From: [Mavor, Kate](#)
To: [A303 Stonehenge](#)
Cc: [Tasker, Nichola](#)
Subject: English Heritage: Application by Highways England for an Order granting Development Consent for the A303 Amesbury to Berwick Down
Date: 24 September 2020 11:02:16
Attachments: [image594733.PNG](#)
[CEO-Highways England DCO-200924-O.pdf](#)

Application by Highways England for an Order granting Development Consent for the A303 Amesbury to Berwick Down

PINS reference No TROI0025

English Heritage will particularly comment on the Highways England's Additional submission Heritage Impact Assessment (HIA) Addendum, addressing the 'new discovery' (as described in the Stonehenge Hidden Landscapes Project Report) and their overarching response addressing the same question from the Secretary of State in the letter dated 16 July 2020.

Drawing file: TR010025 / TR010025-001755-Figure 13.3A and B Proposed Public Rights of Way Revision 3.pdf

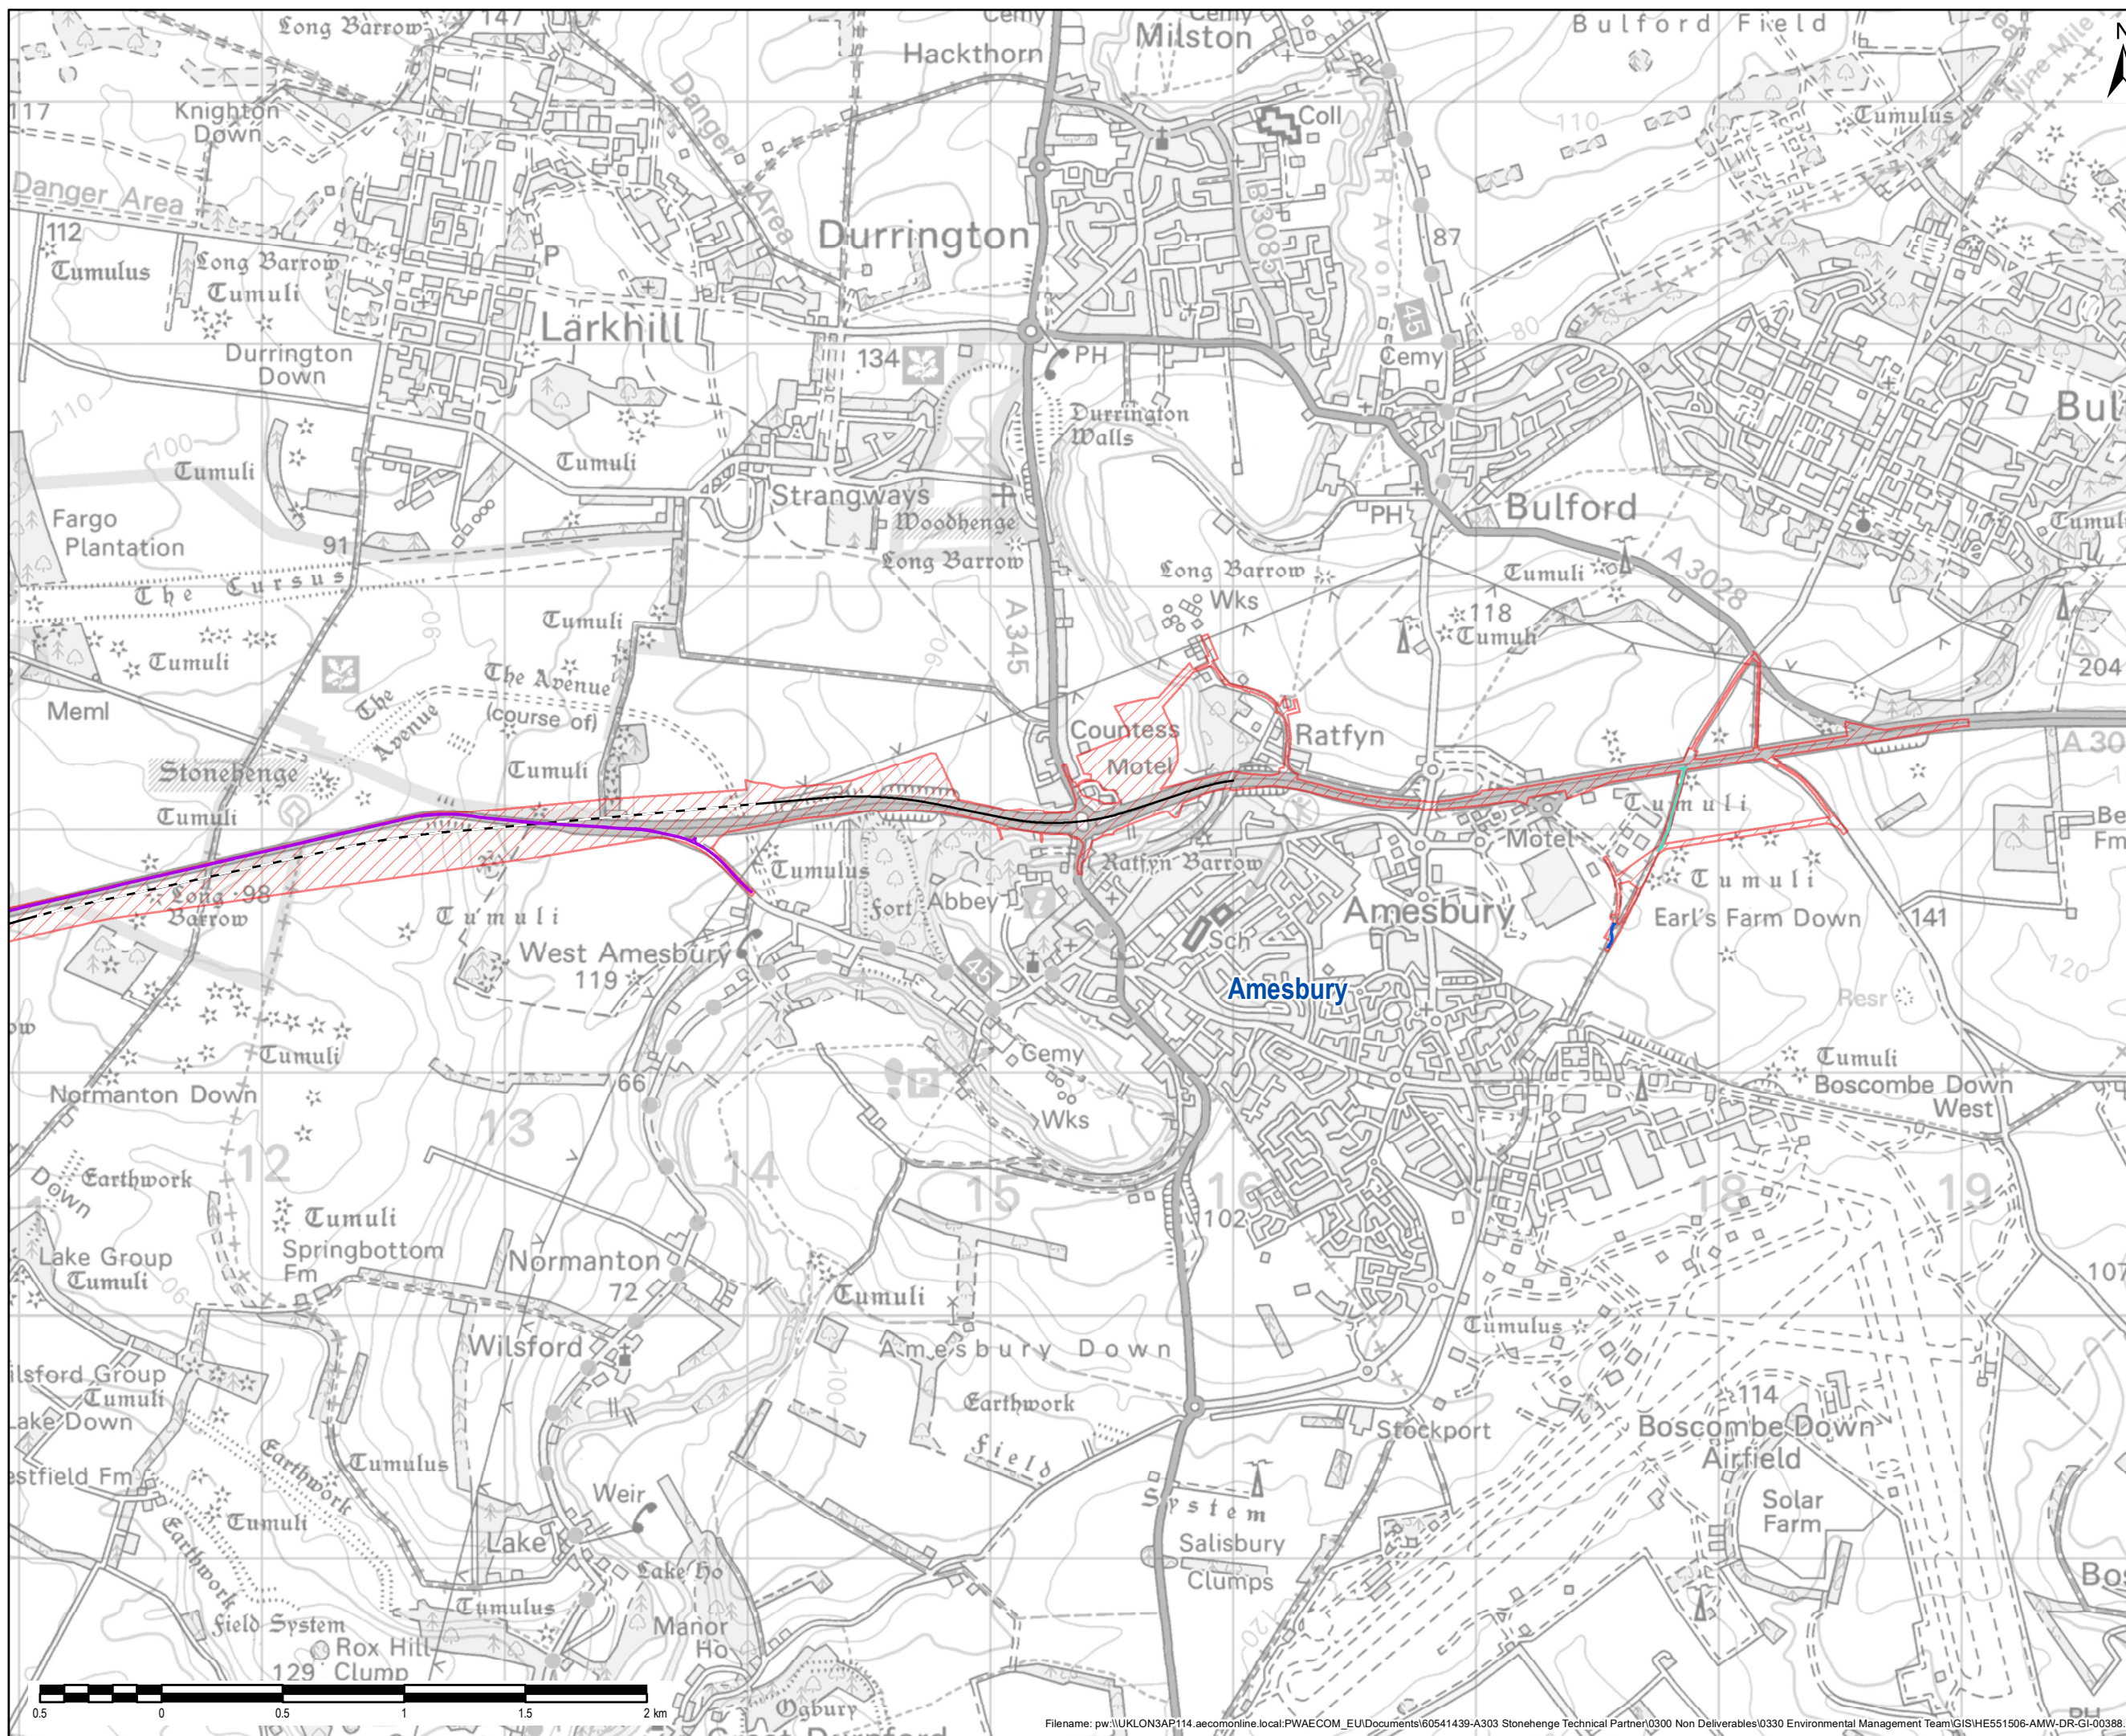
1. We note the corrections by Highways England to figure 13.3A showing the proposed restricted right of way across land that English Heritage manages at the Stonehenge Visitor centre.
2. The negotiations over this proposed restricted right of way are on-going with the applicant Highways England and remain under discussion as noted in our Statement of Common Ground with Highways England and also our comments on Applicants Consultation report on Changes to the DCO application [AS-066 & AS 067] (Deadline 8a).
